AOWE ATO INSTALLATION REPORT

RE: Typo on Construction Authorization

Briarwood Bluff Lot 17

27 Pine Vista Way Sanford, NC 27332

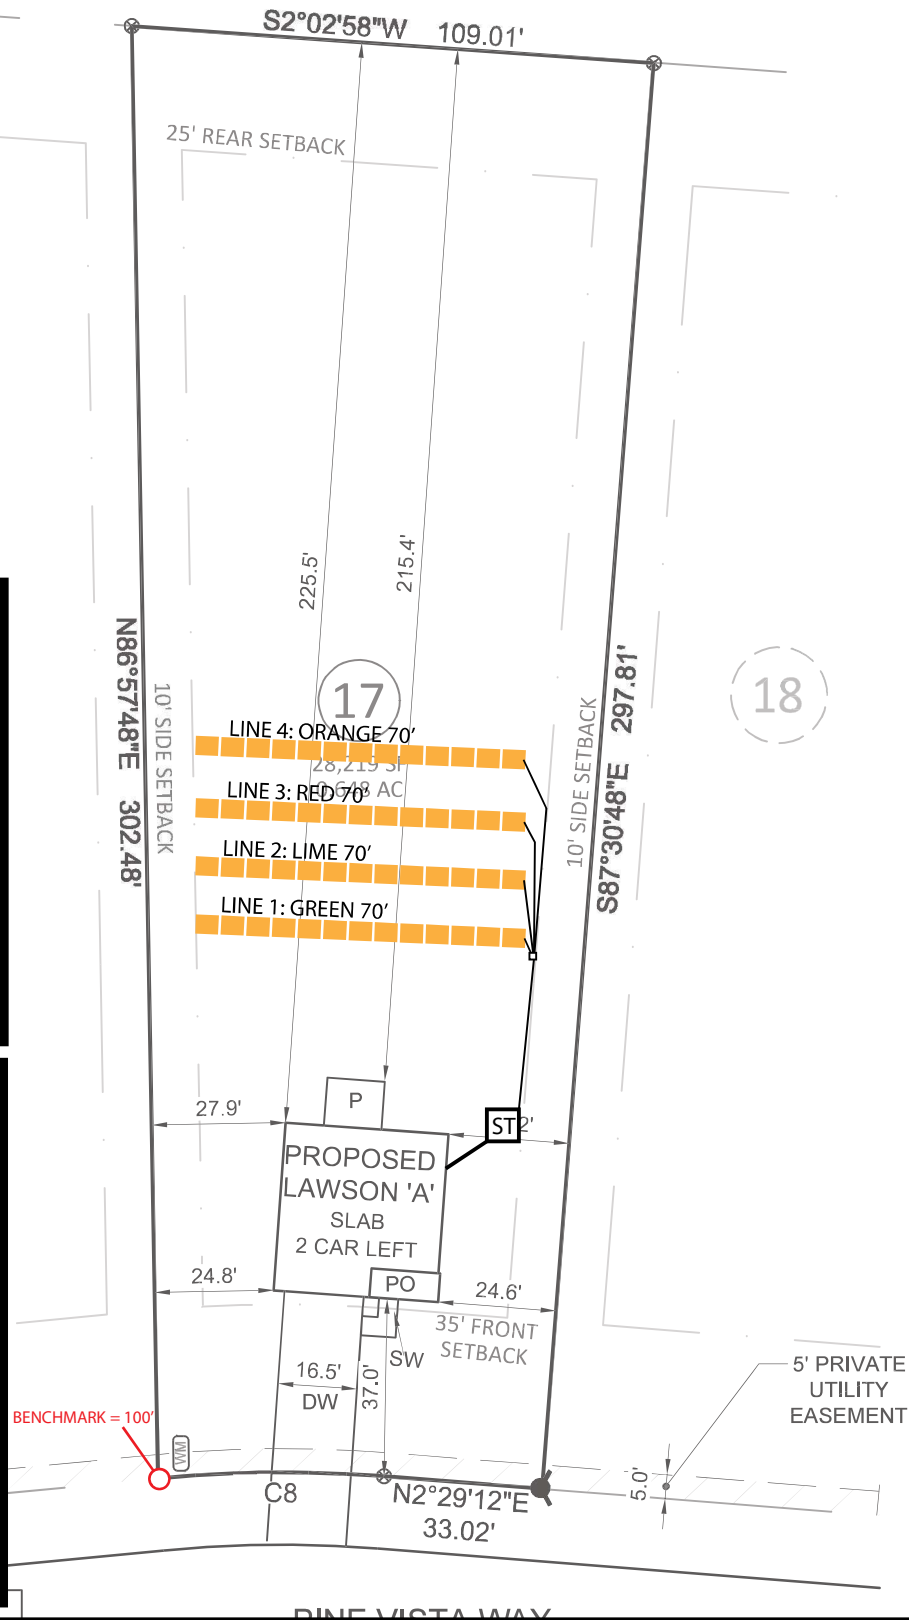
The original drawing for this system called for 280' of line according to the drawing, but had a typo on the construction authorization as 346'. The system was installed accurately according to the design as 4x70' lines. The installed system meets all state requirements.
